APPLICATION NO: 23/00264/TRTPO

DESCRIPTION: TPO 777 and TPO 55 - Application to prune 2 trees

LOCATION: Mornington House 18 Heath Hill Road North Crowthorne

Re: Tree Works Application for – Mornington House 18 Heath Hill Road North Crowthorne

**Tree Protection**

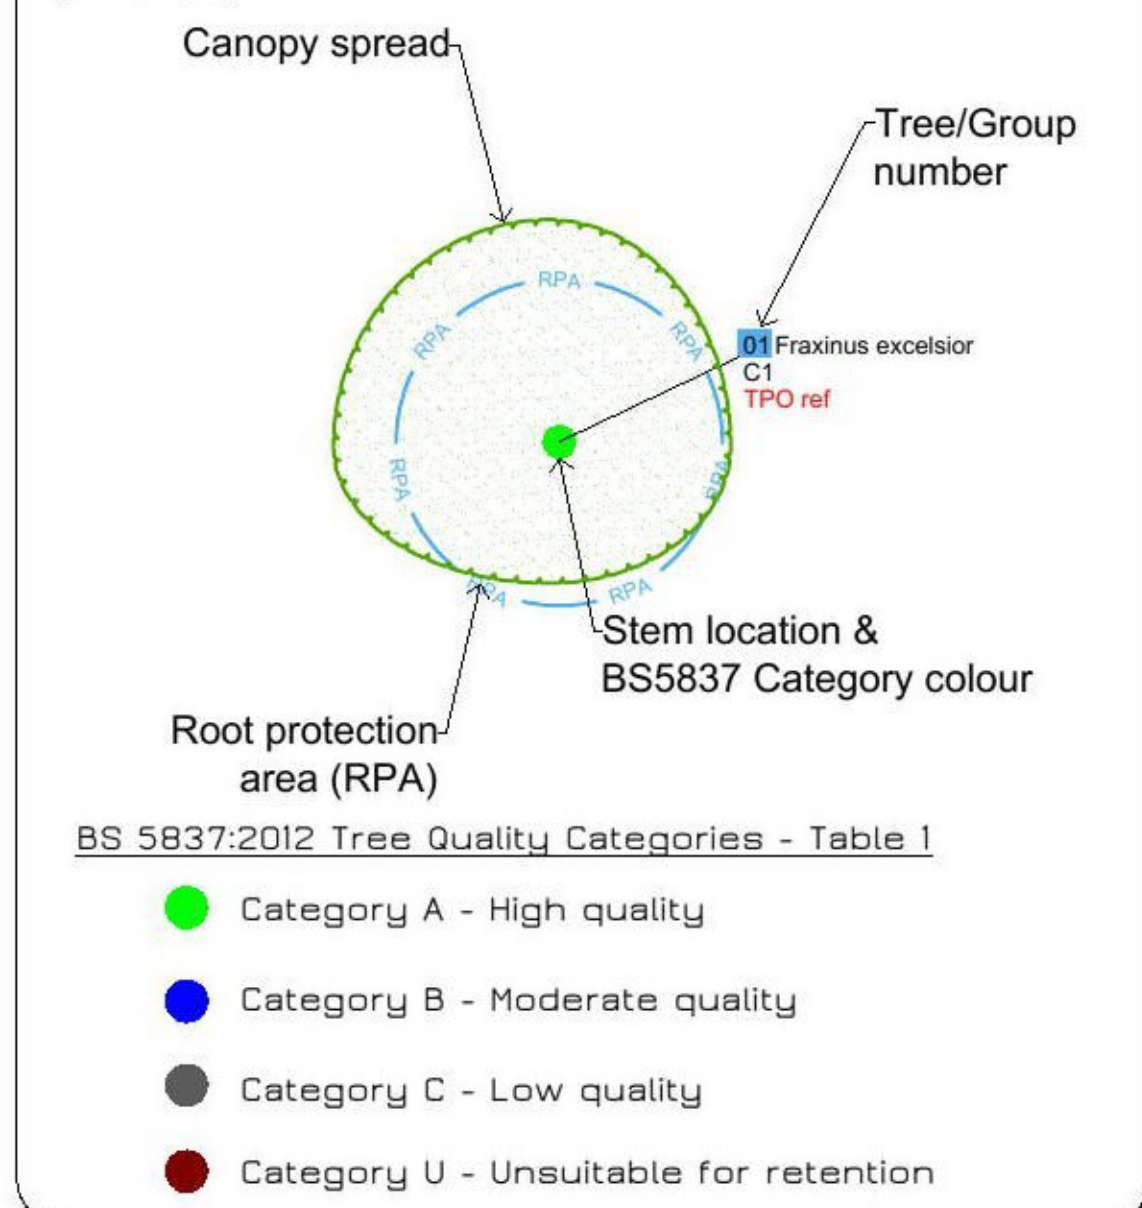
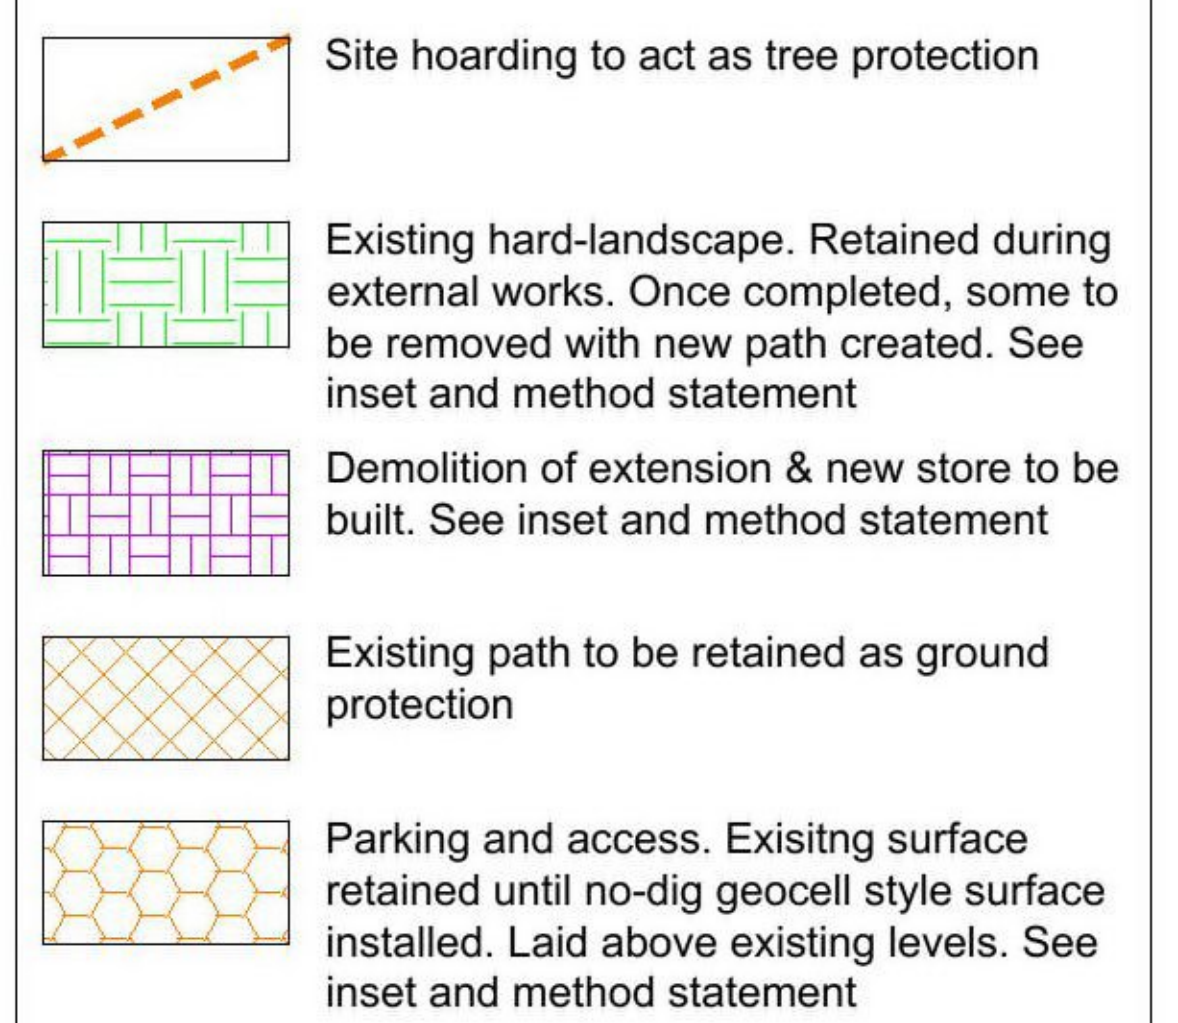
- 0 Tree Works Description - Please provide pre & post pruning dimensions for each tree.
